North Lincolnshire Green Energy Park Project – Examination of Development Consent Order

Summary Written Representations on behalf of AB Agri Limited
15 December 2022

Planning Inspectorate Ref: EN010116
Interested Party Ref: 20032351

Drawing Number	Drawing Title	Revision
NLGEP-FCE-XX-XX-DR-Y-5001	Indicative Site Layout	P0

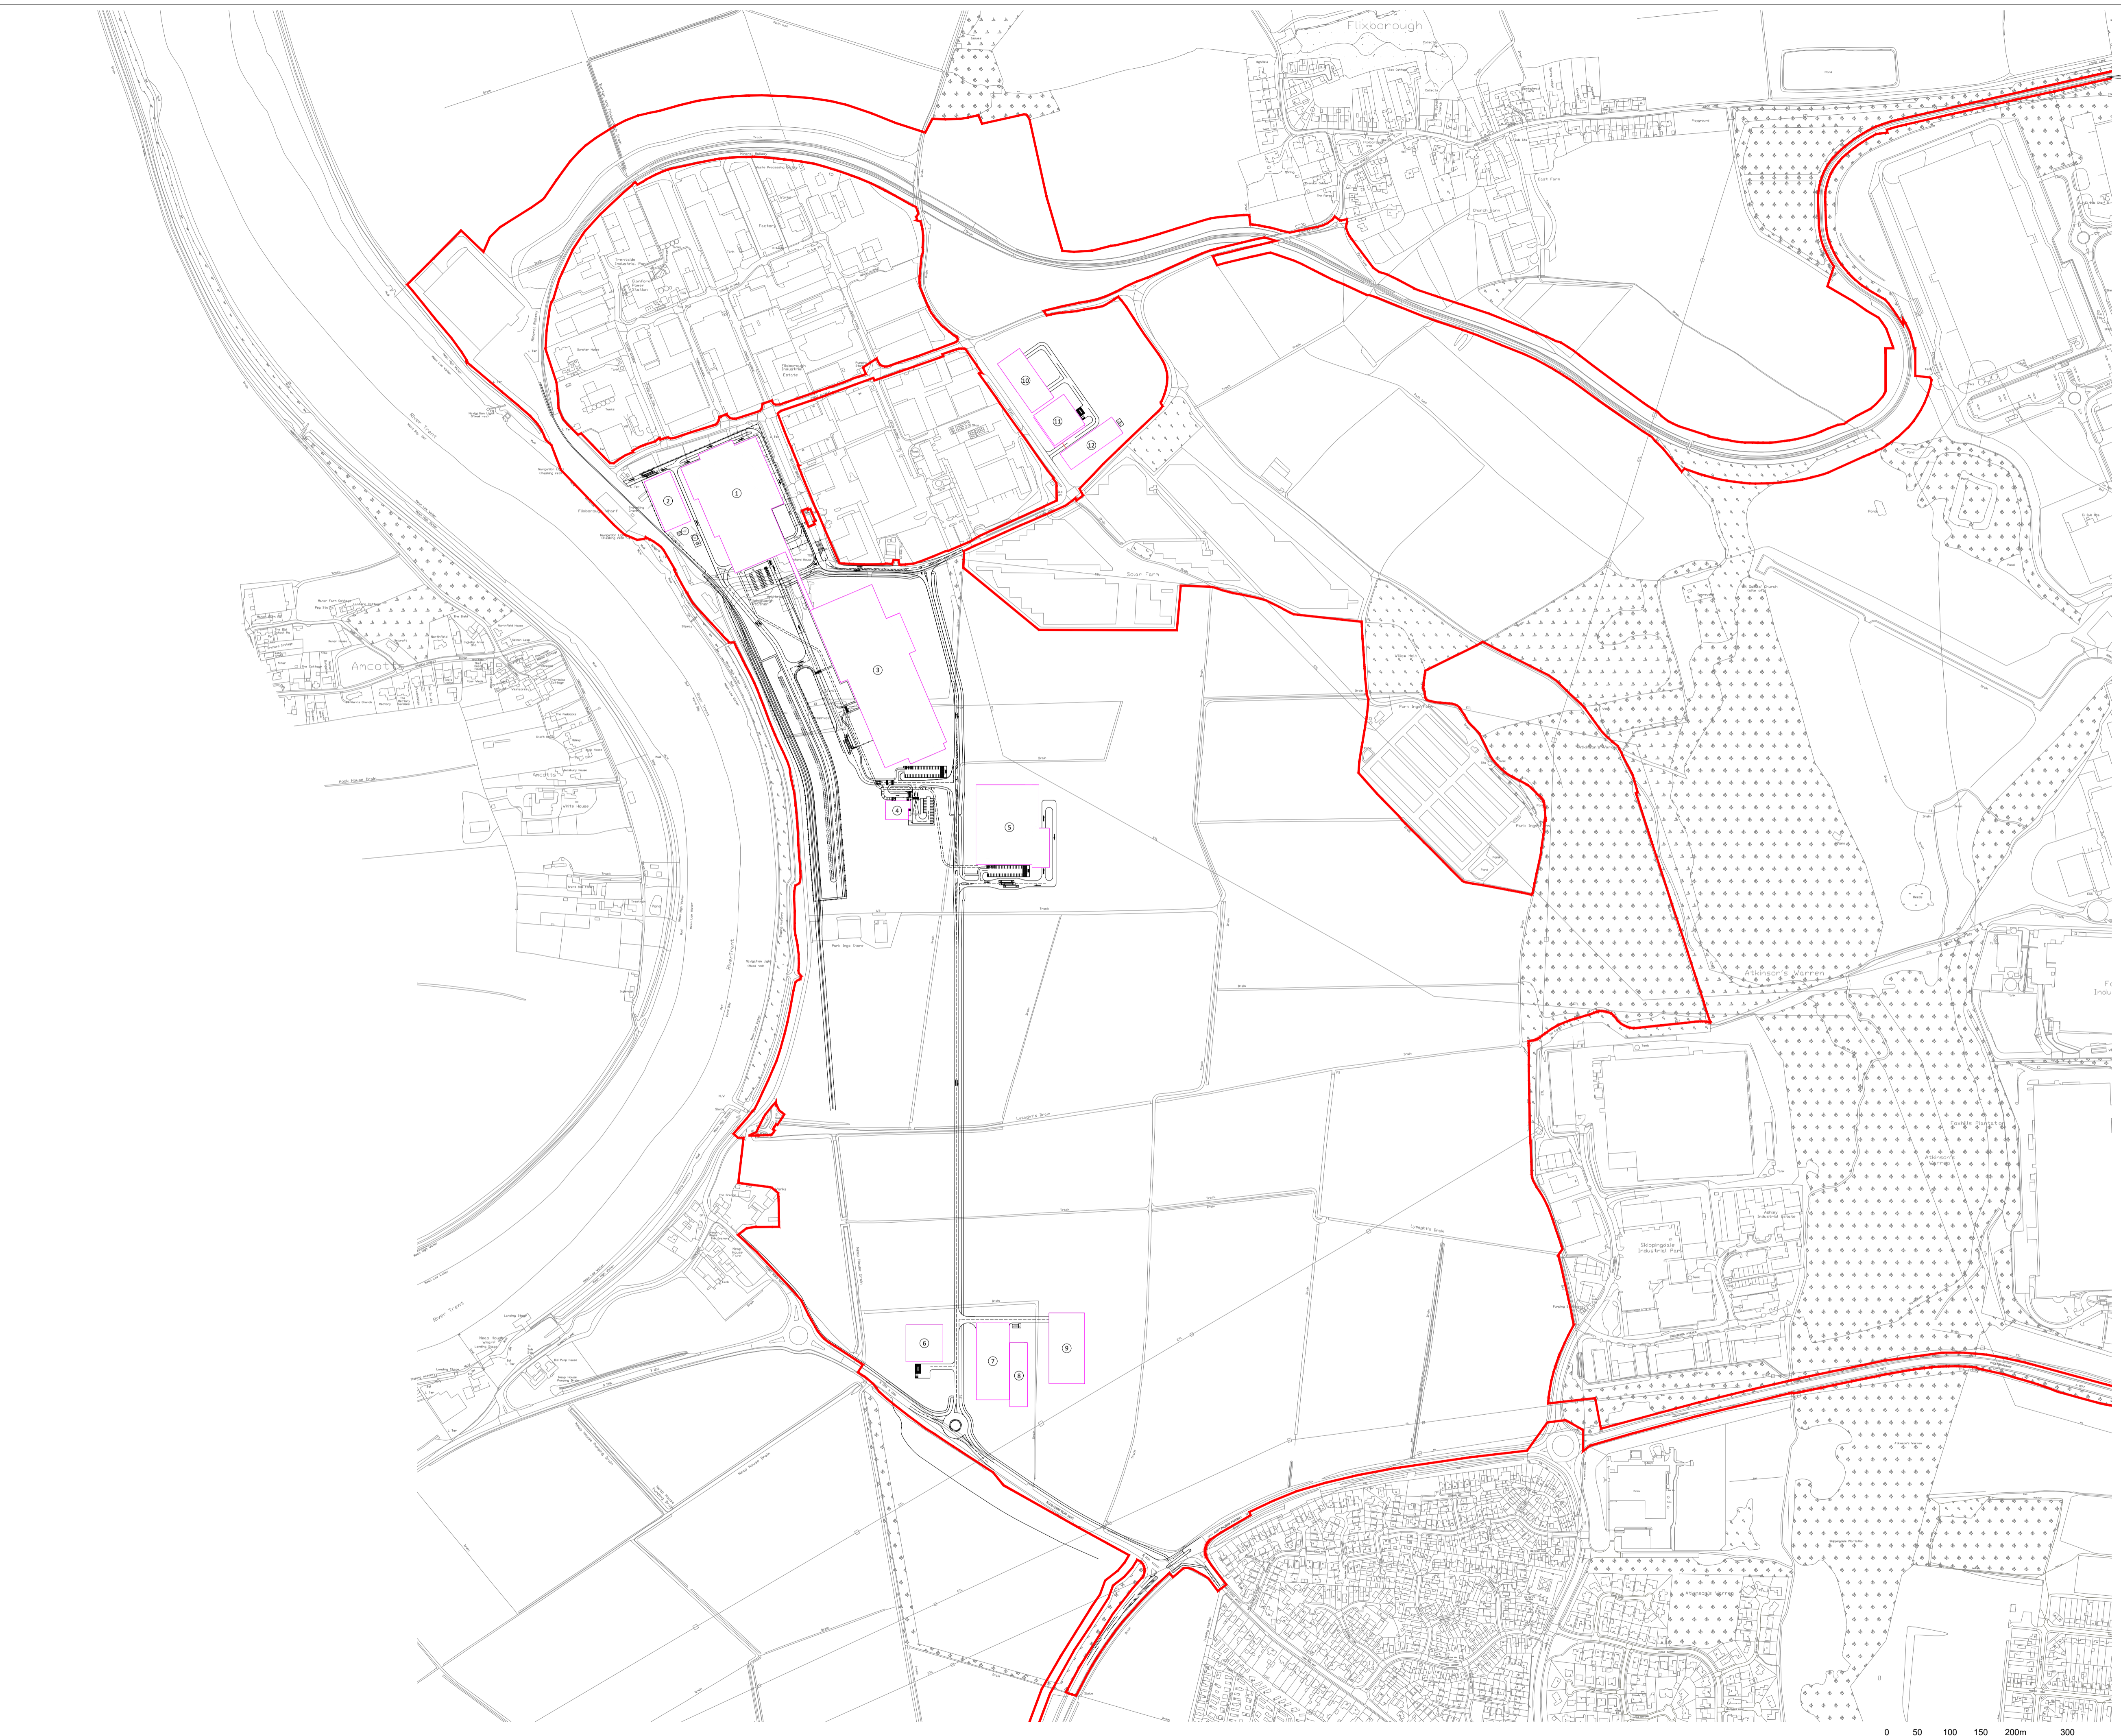
- 1.7 **Access to AB Agri's facility** - AB Agri operates 24 hours a day, 7 days a week, all year round (except for Christmas Day) and requires constant access as a result. As a result, AB Agri seeks a range of measures to be included in the construction traffic management plan to be secured by a condition. We request the Applicant to engage with AB Agri on traffic flow and construction planning as per their commitment to do so.

- 1.8 **Temporary Acquisition** - possession for three years of approximately one third of the perimeter of the AB Agri's site and one half of its road frontage will significantly compromise AB Agri's enjoyment of its land, not least due to AB Agri requiring full access around all buildings and temporary land, and the biosecurity and contamination risks that would arise. The Applicant has not demonstrated a compelling case to take temporary possession in light of the potential damage that it may cause AB Agri's business.
